NEPCO  
P.O. Box 714  
Monument, CO 80132-0714

March 31, 2020

**Reference: Rollin Ridge Estates Final Plat**

**General Concerns/Questions related to Rollin Ridge Estates Final Plat**

PCD File No. SF-19-022

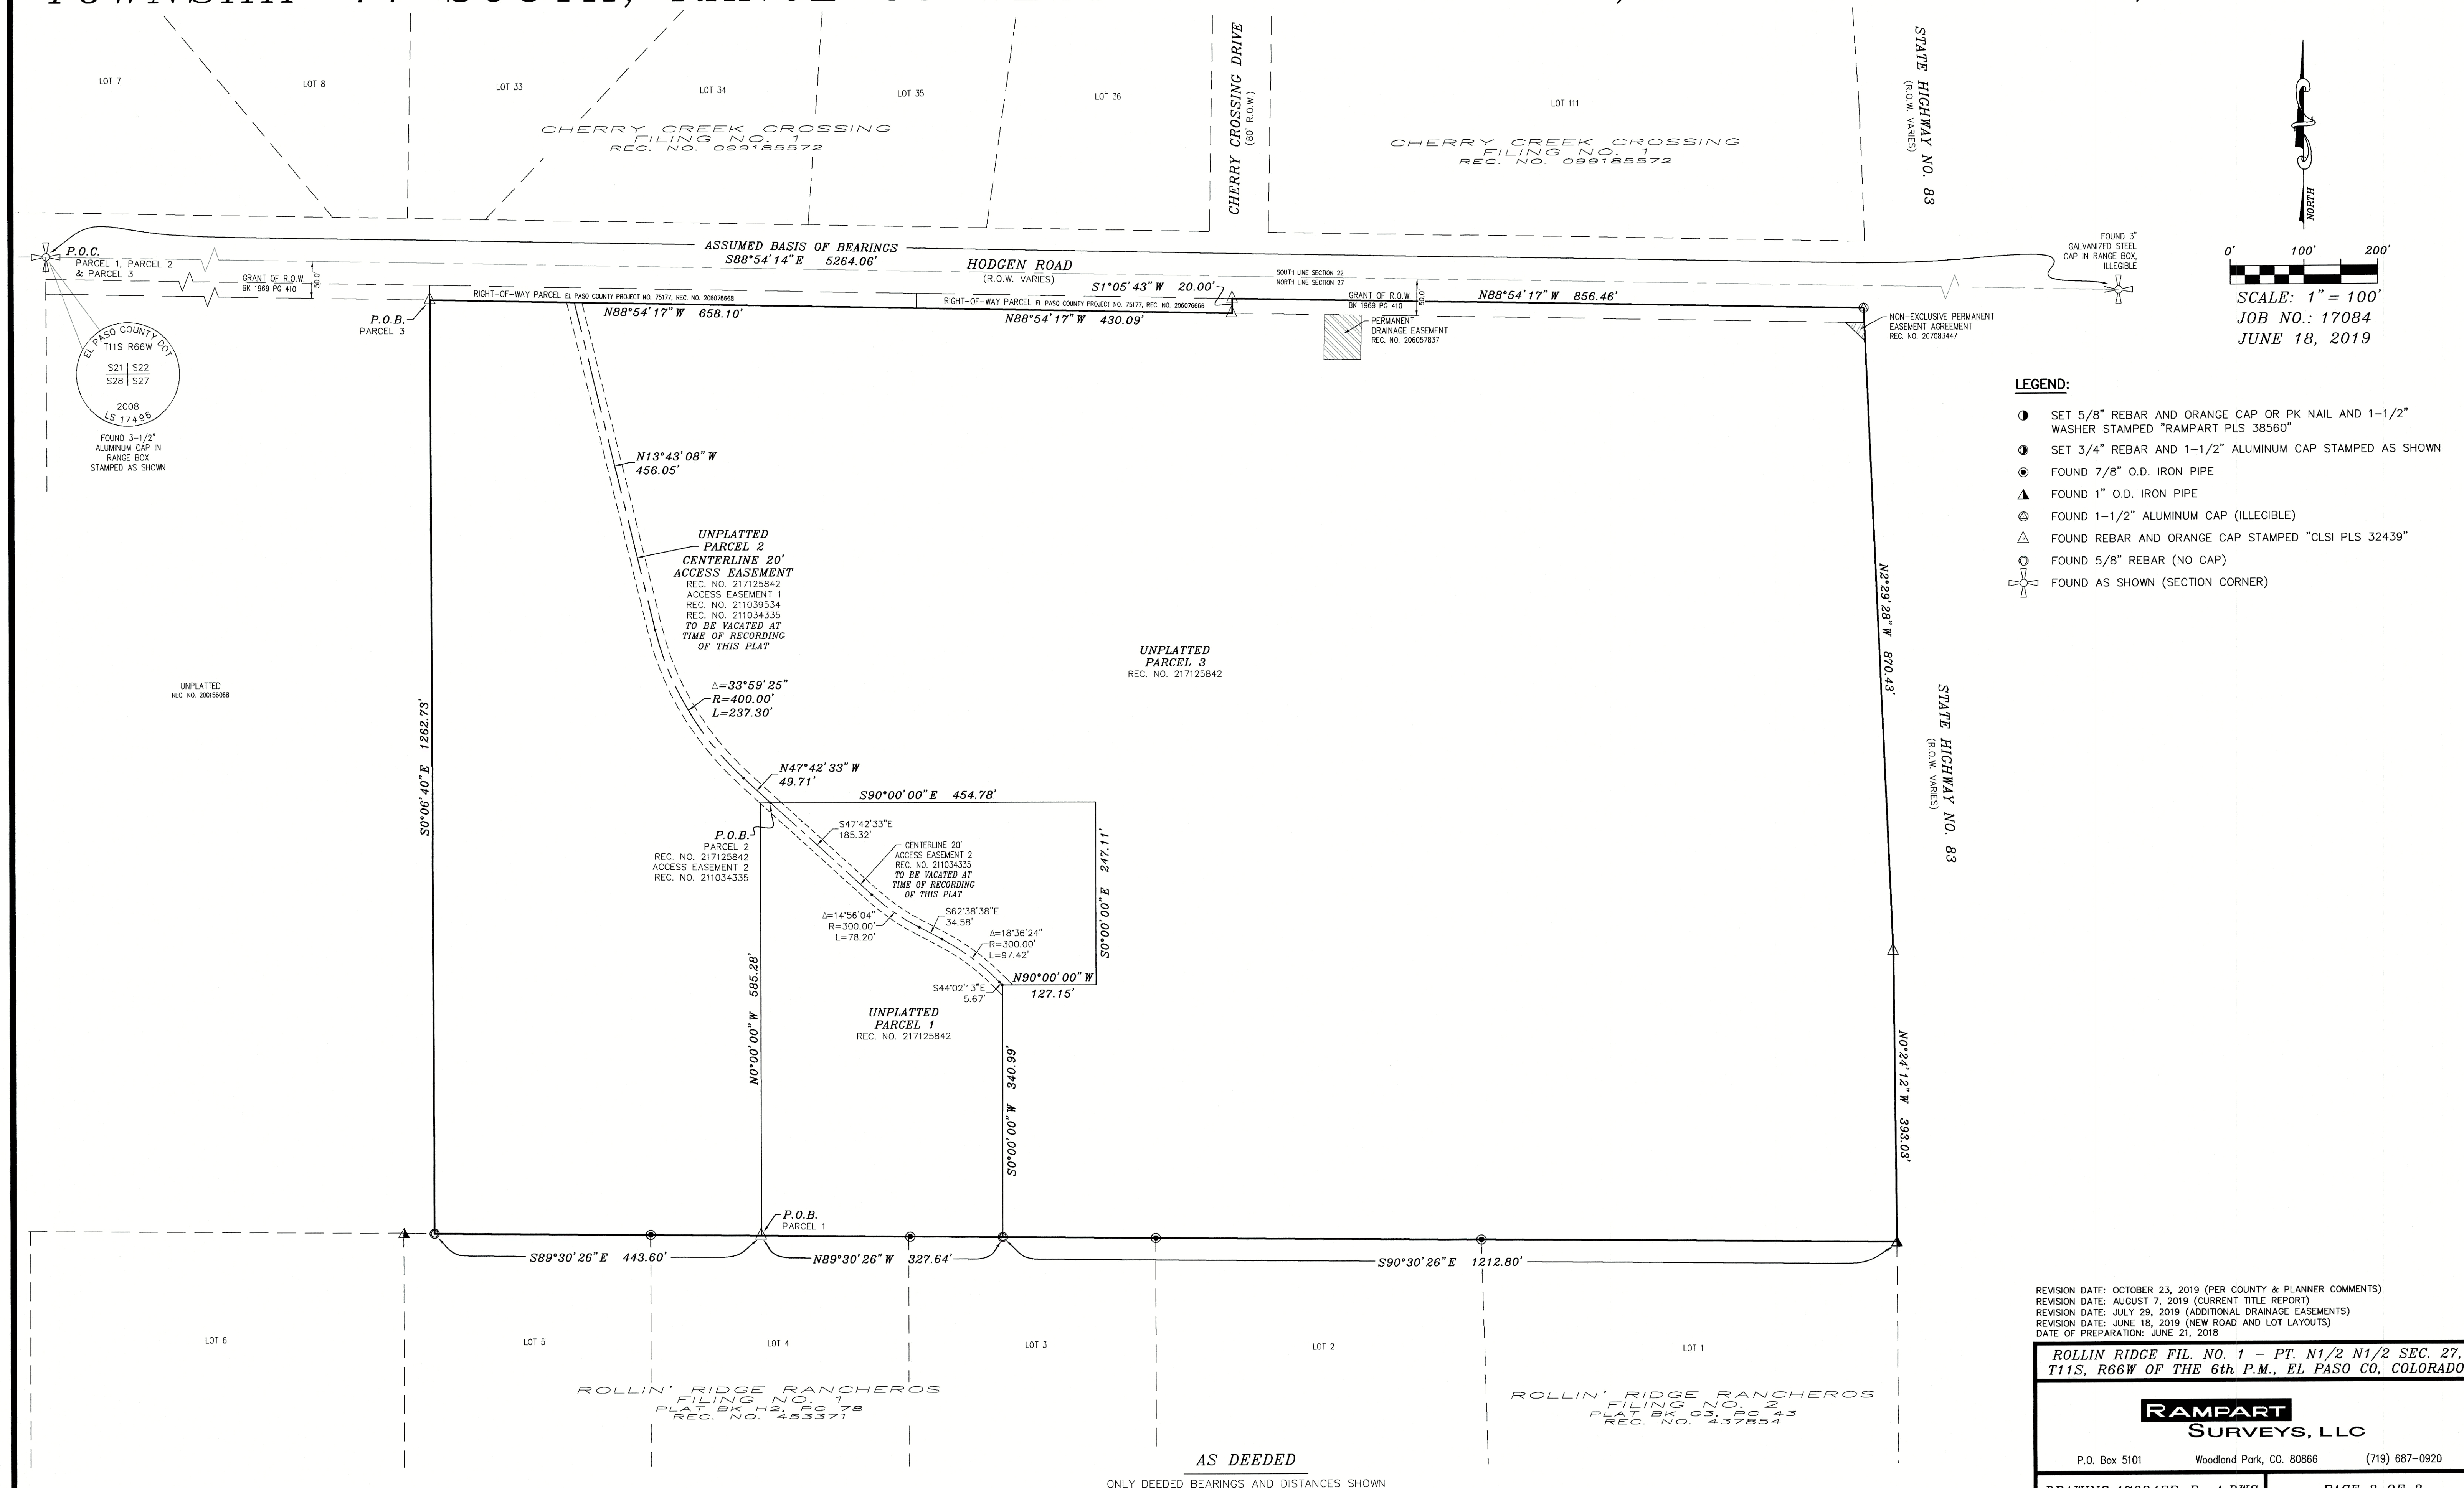
1. There appears to be some confusion with the proper version of some of the documents recently submitted by the developer. For instance, the Letter of Intent, page 3, and the Final Plat, Note 10, both state that the development is within the Academy School District No. 20. This appears to be incorrect, but was correct on the earlier version of the Final Plat (D38 district). Recommend that you review all new documents very closely!
